Response from the South Downs National Park Authority to the Examining Authority’s written questions and requests for information (ExQI)

The South Downs National Park Authority’s (SDNPA) response to the questions asked of it are contained in the table below, against the Examining Authority’s original question for ease of reference. These responses are provided for Deadline 2 of the examination (15 June 2023).

View Location: VL 14 (Proposed)  
 View Description: Itchen Way  
 Winter / Summer: Summer  
 Date / time taken: 14:07 17/09/2021

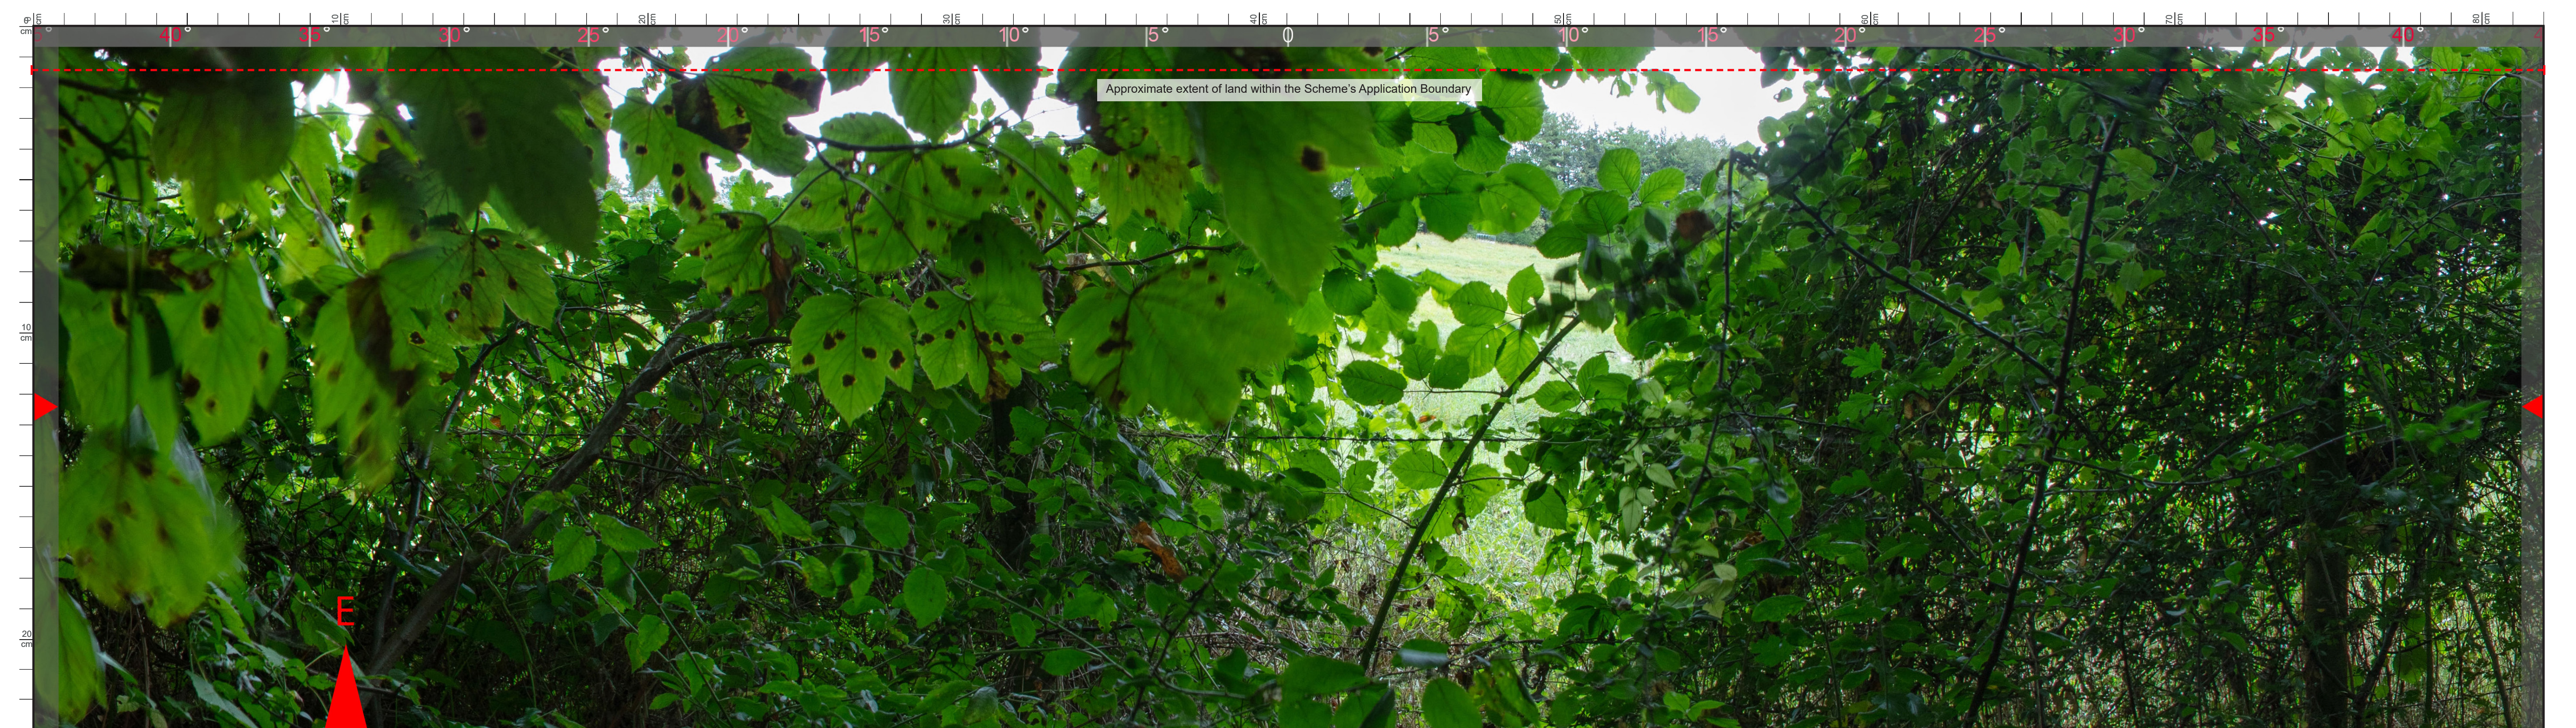
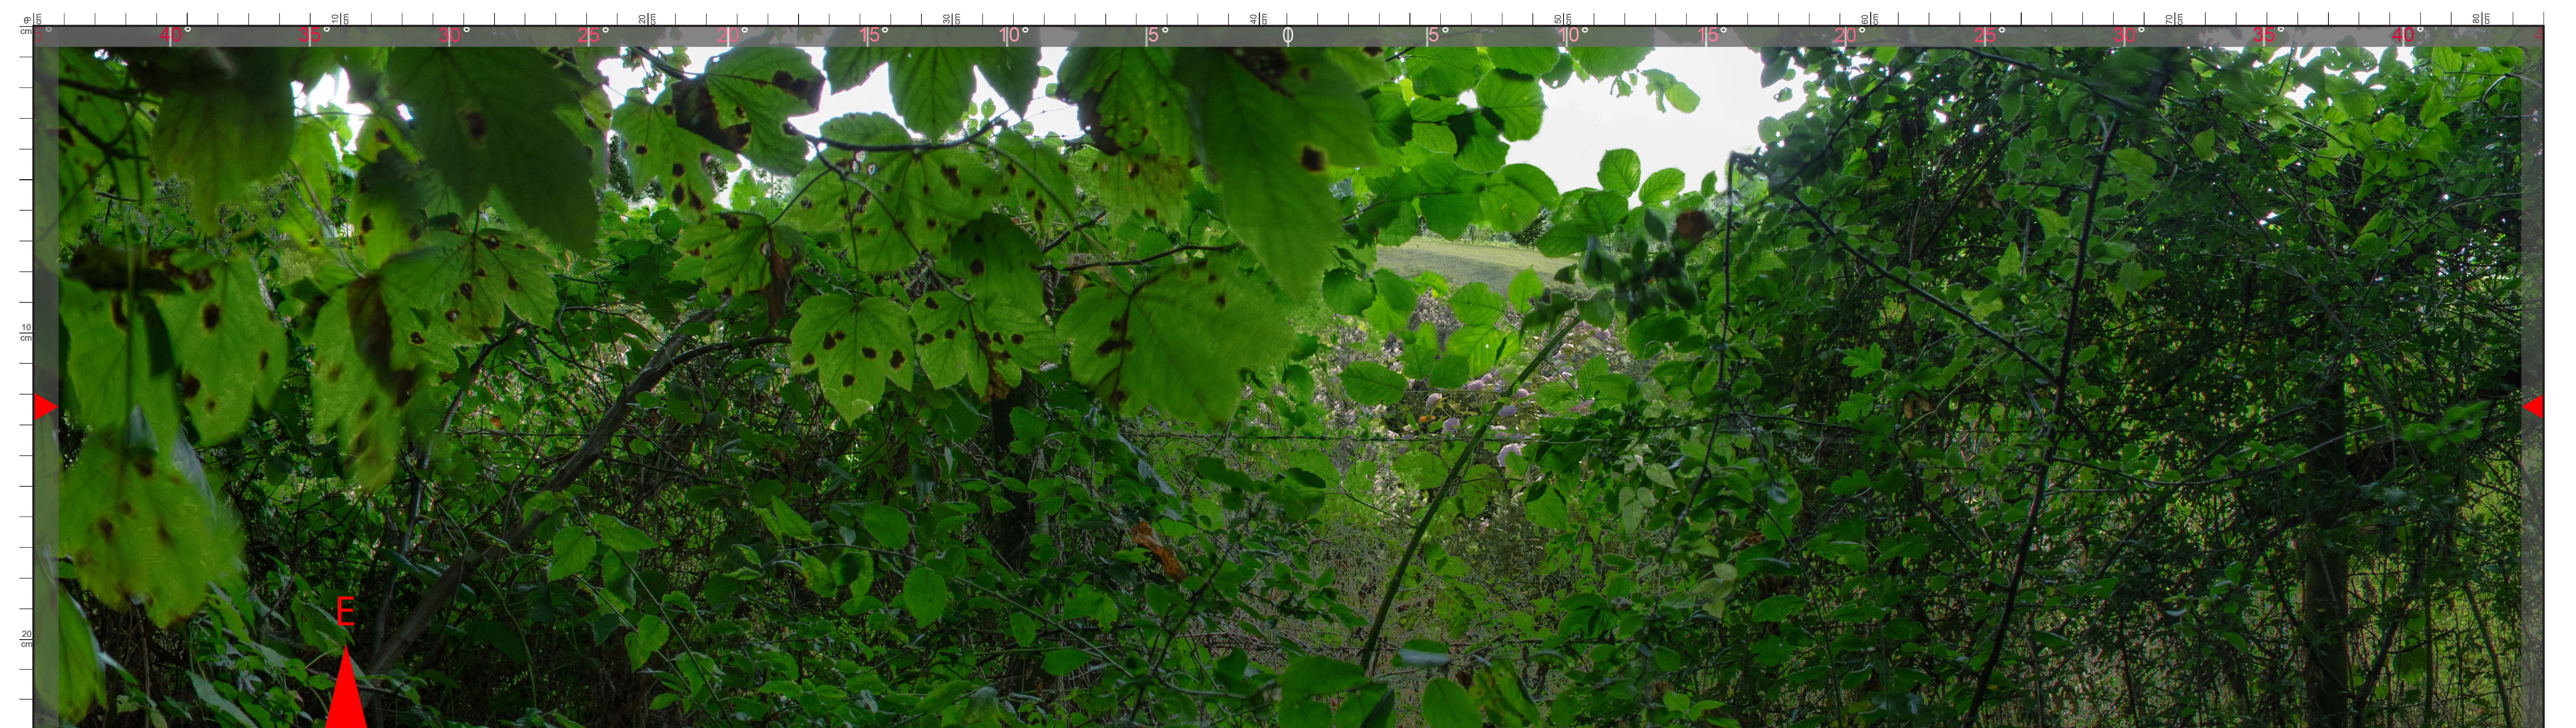
Question Reference	Examining Authority Question	SDNPA Response
		<ul style="list-style-type: none"> • LV17 - The SDNPA are not convinced that the embankments are suitable in terms of gradients for the creation of chalk grassland. • LV19 - Whilst this is welcomed in principle it is hard to see how the attenuation basins can be designed to appear as naturalistic elements as they are not characteristic of the chalk downland. <p>The SDNPA is not satisfied with either the baseline photographs or the visualisations. Both the baseline photographs and the visualisations are presented as panoramas to be printed at A1. Unless the images are viewed printed at the correct size, they will give a distorted impression of the landscape.</p> <p>Paragraph 3.1.18 of our Written Representation, sets out the SDNPA's concerns with the visualisations (document APP-069), which are considered to underestimate the effects of the proposals. In particular</p> <ul style="list-style-type: none"> • Planting growth appears optimistic, particularly at Viewpoint 1; • In Viewpoint 14, existing trees are shown along the edge of the motorway however these are proposed to be removed; • Structures such as the attenuation ponds are not shown, and • The road, particularly at Viewpoint 14, is not how it will actually look. There are no vehicles, no barriers, no road markings etc.

Question Reference	Examining Authority Question	SDNPA Response
		<p>The SDNPA informed the applicant of our concerns with the visualisations. It is noted that one of these concerns has been addressed at Deadline 1 submissions with the production of a new visualisation for VP 14. Whilst the SDNPA reserves the right to comment further on the Deadline 1 submissions (as set out in our covering letter with this submission). The revised image shows that the original visualisation misrepresented the impact of the changes.</p> <p>In addition, there does not appear to have been an accompanying revision of the ES Appendix 7.4 Schedule of Visual Effects.</p> <p>The SDNPA considers that it would be helpful for the night time photographs and visualisations to be presented alongside a daytime image.</p> <p>A summary of the further mitigation measures which the SDNPA considers should be included in the proposals are set out in Paragraph 3.1.27 of our Written Representation and above in the answer to Q12.1.3</p> <p>The Draft DCO should include a specific reference to the OLEMP/LEMP to secure all relevant mitigation referred to in the Environmental Statement.</p>
